Planning App. Ref.	3/2025/0801 - Adjoining LPA enquiry – RVBC
Location	Land to east of Salesbury View, Wilpshire
Proposal	Proposed erection of new residential development comprising 80 new homes, including 30% affordable housing, open space and associated infrastructure.

Strategic Planning Response:

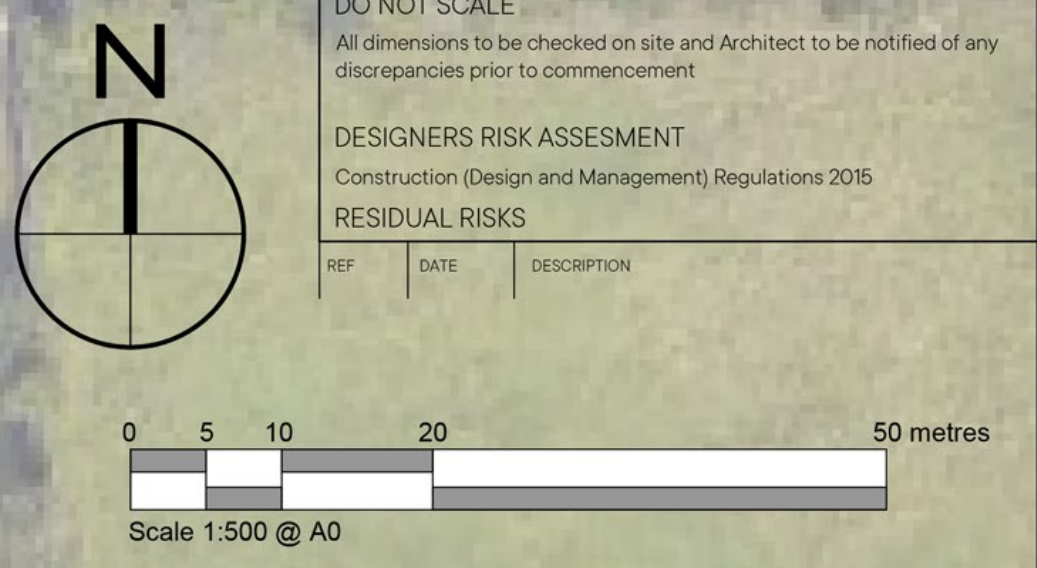
We broadly agree with those findings and acknowledge that Allocation H195, once built out, would have a similar level of visual impact to these proposals. Having reviewed the Landscape Masterplan, we feel the proposed scheme would benefit from some additional planting along the south boundary. BwD trust that issues relating to visual impact from both within the RV and BwD boundaries will be taken into account in the assessment of the application. If the application were to be recommended for approval, BwD would expect suitable mitigation measures would be secured through condition to minimise this impact.
